**KIRKLEES METROPOLITAN COUNCIL
INVESTMENT & REGENERATION SERVICE**

**DELEGATED DECISION FOR APPLICATION FOR CERTIFICATE OF
LAWFUL DEVELOPMENT**

Reference no.: 2025/CL/92578/E

Description: Certificate of lawfulness for proposed removal of
existing garage and erection of replacement garage

Scale 1:50

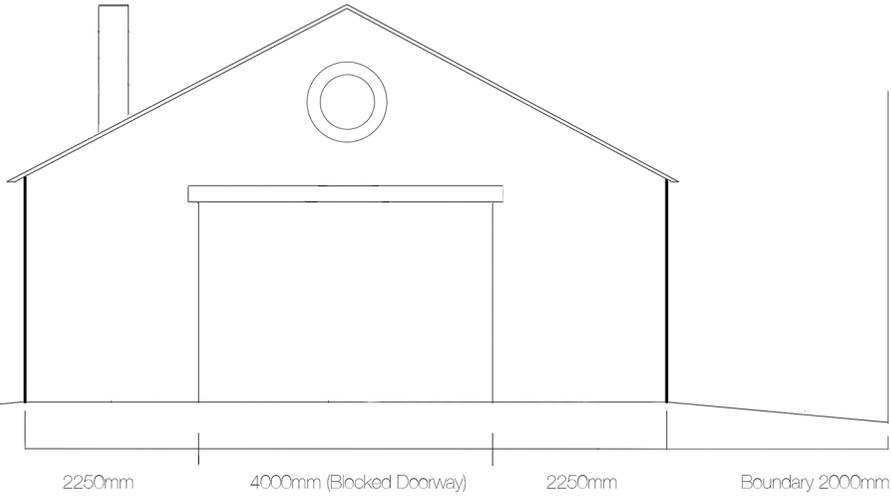
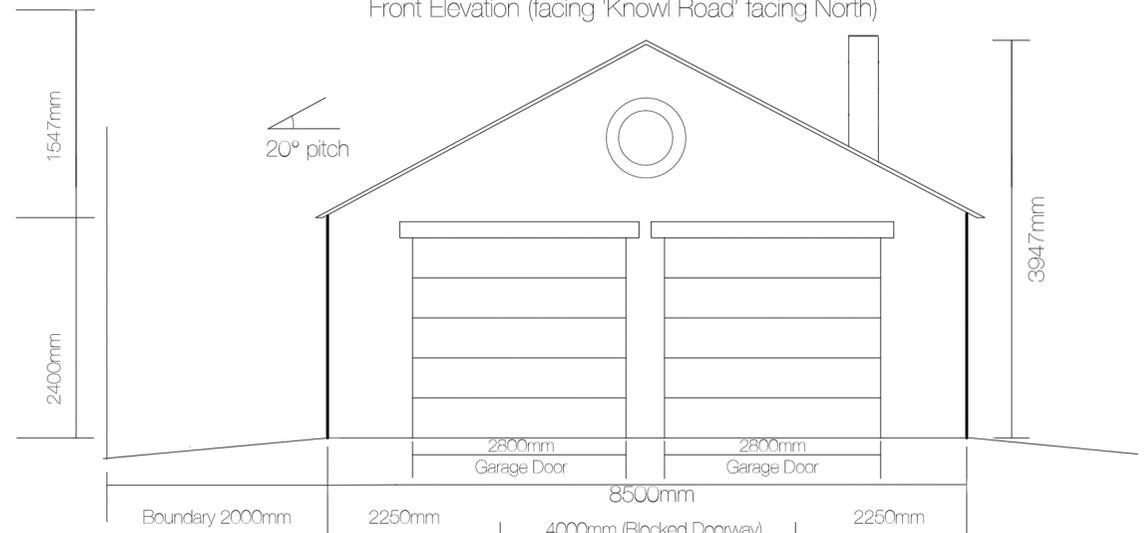
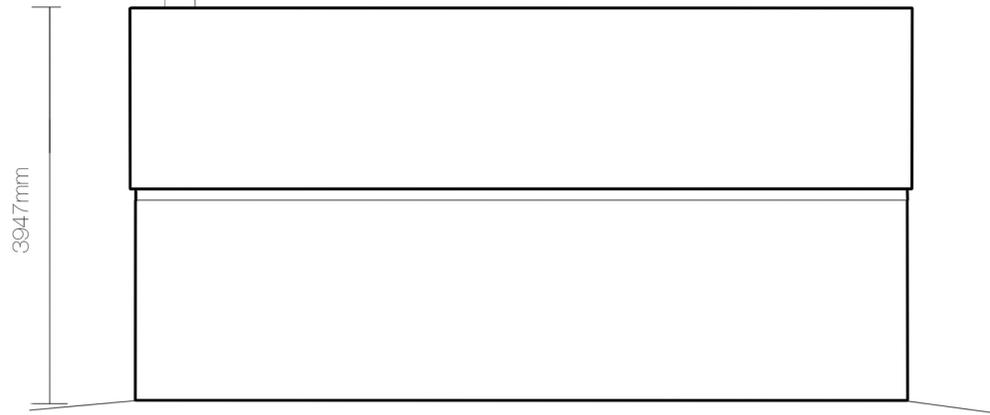
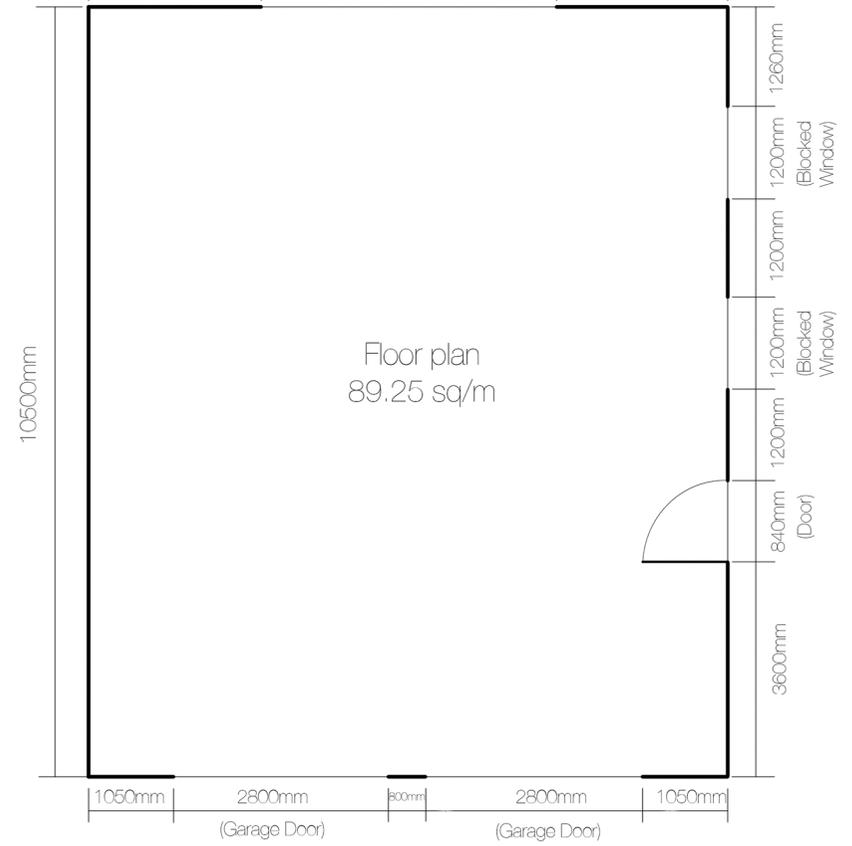
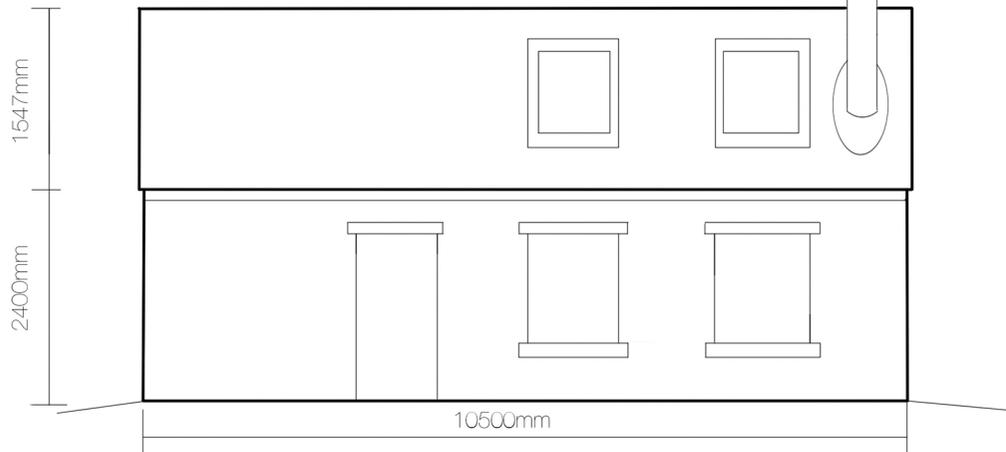
The agent has been contacted regarding the proposal as the plans do not appear to be to scale. In addition, it appeared from the plan the proposed flue would result in the structure being higher than 4 metres as required within the regulations. In response, the Agent has submitted an amended plans which rectifies the issue regarding the scaling of the plans and has seen the reduction in height of the flue. The amended plan was received on 29th October 2025 and forms the basis of this assessment.

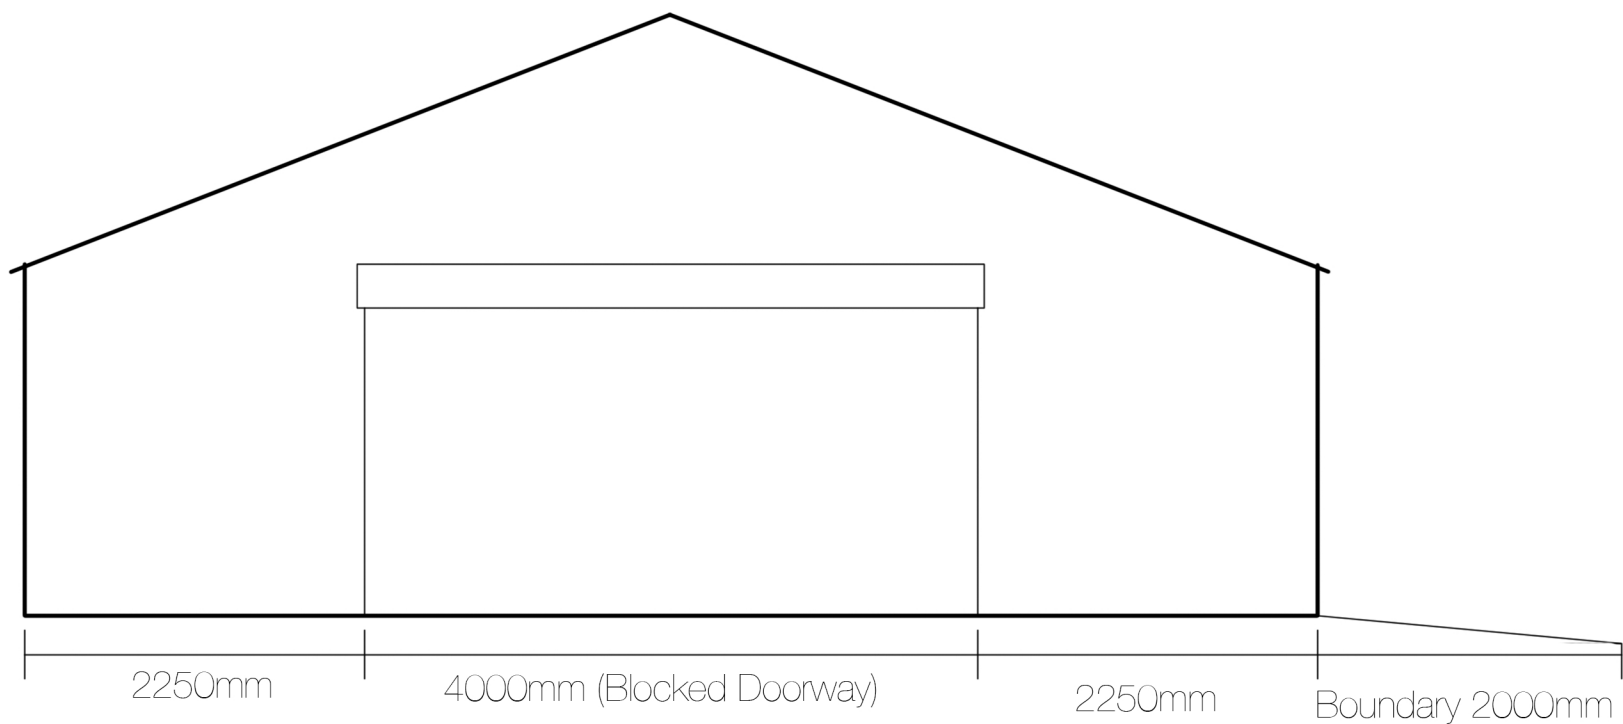
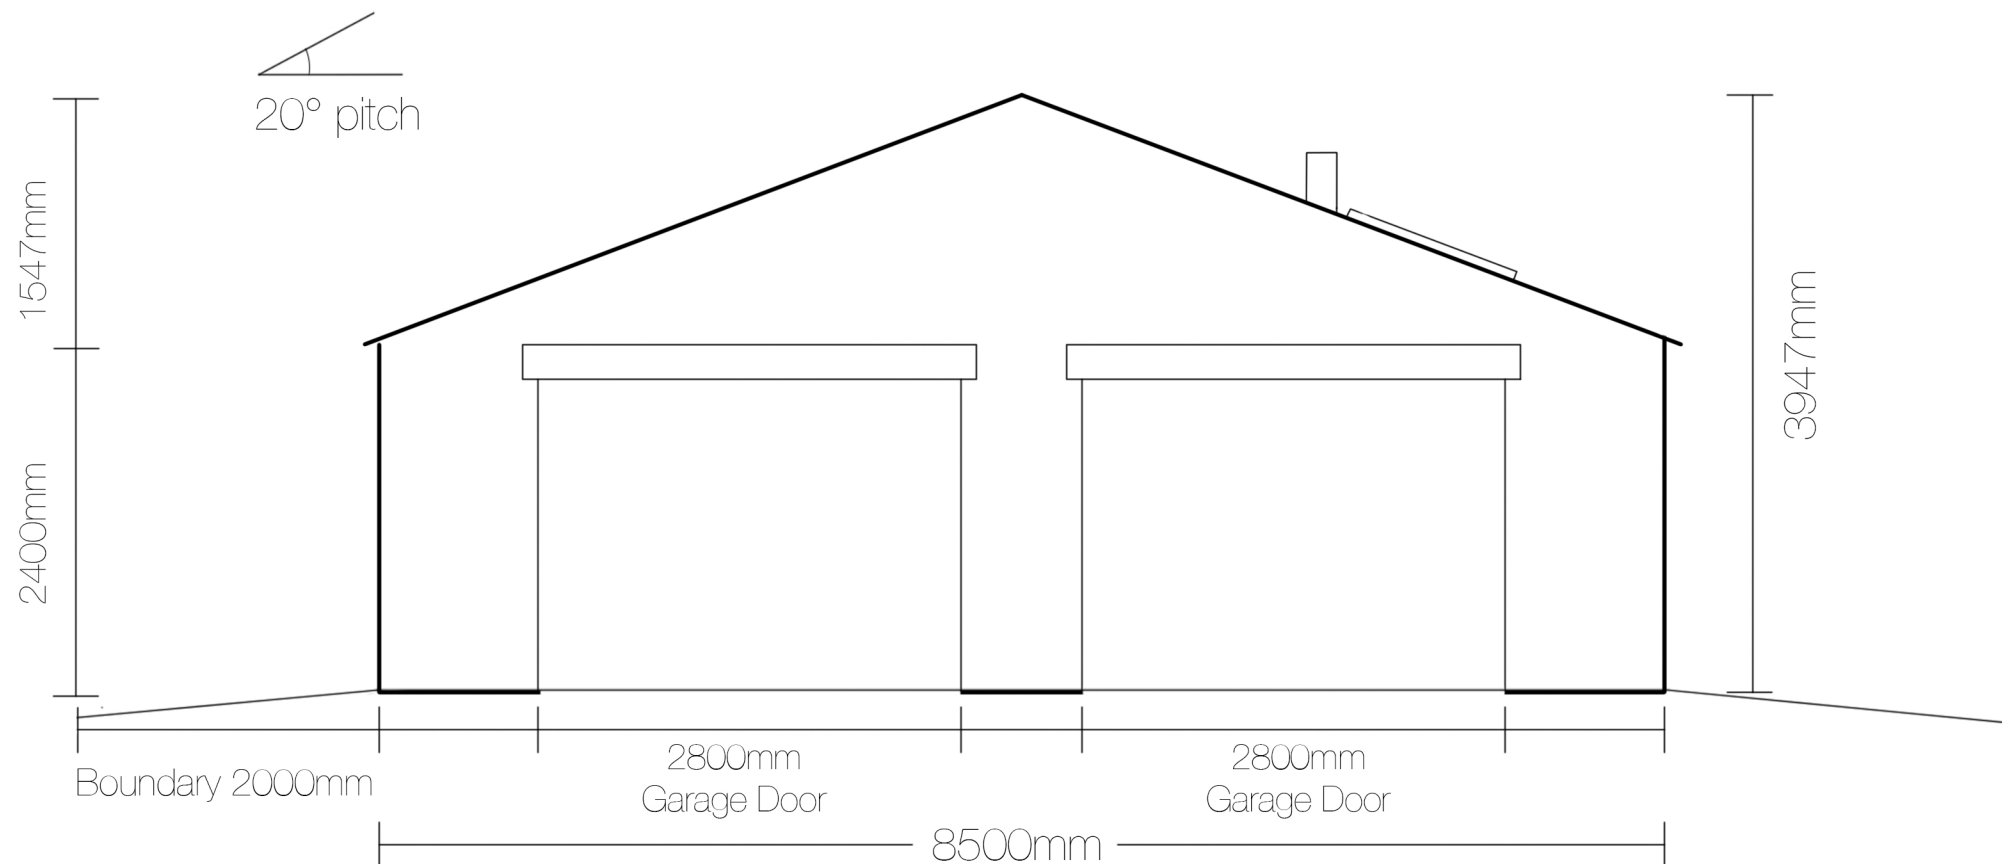
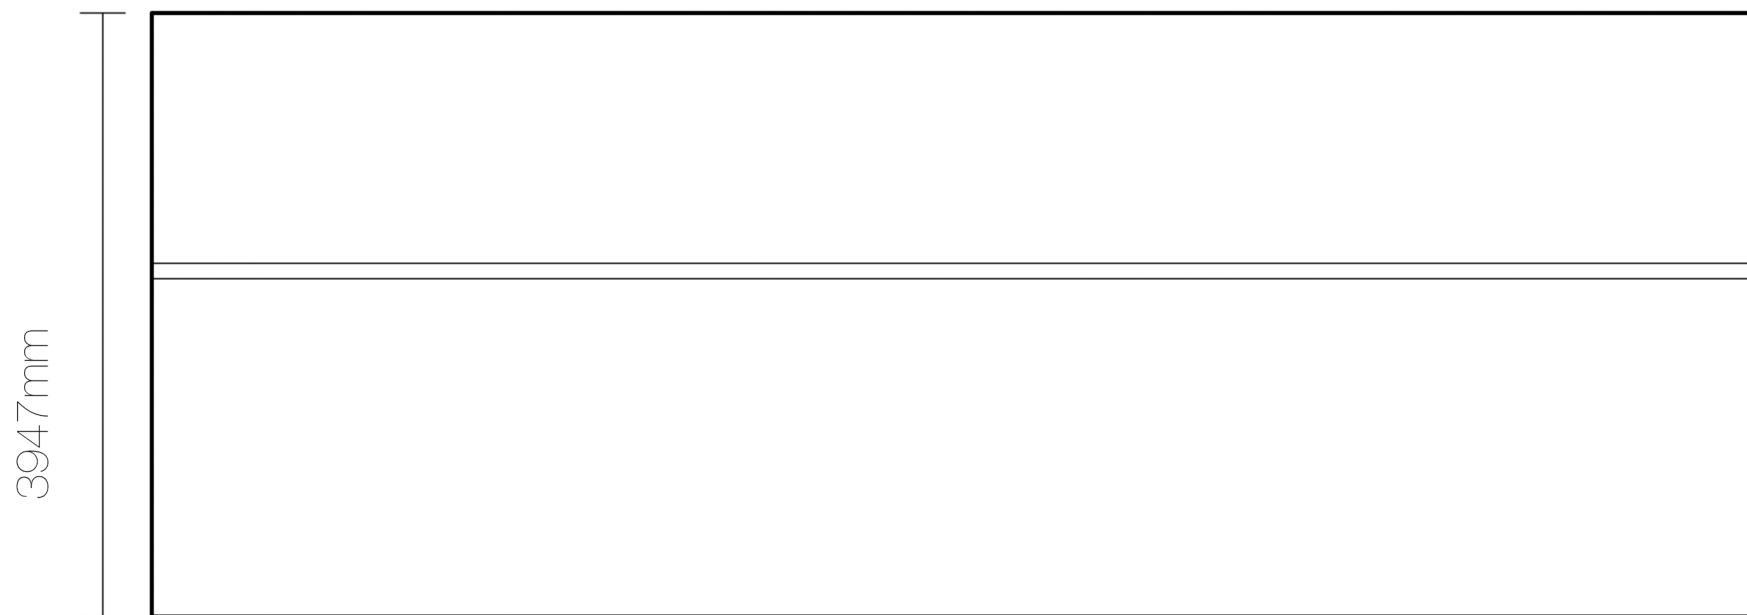
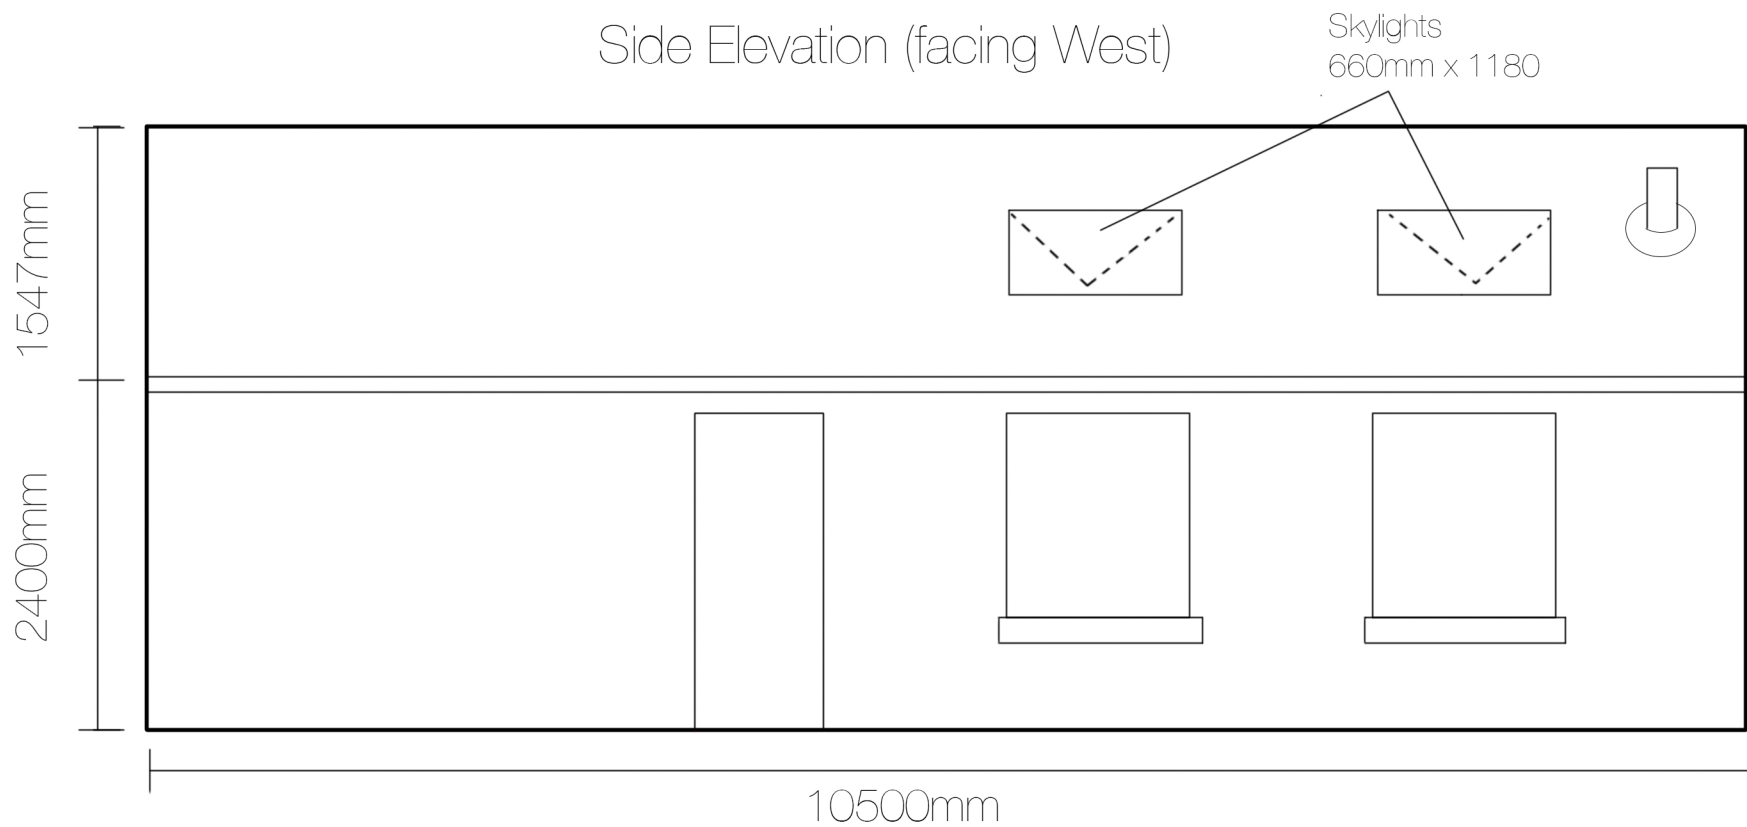
Comment: *The amended plan demonstrates that the building would be set in from the boundary by 2 metres and would not exceed 4 metres in height.*
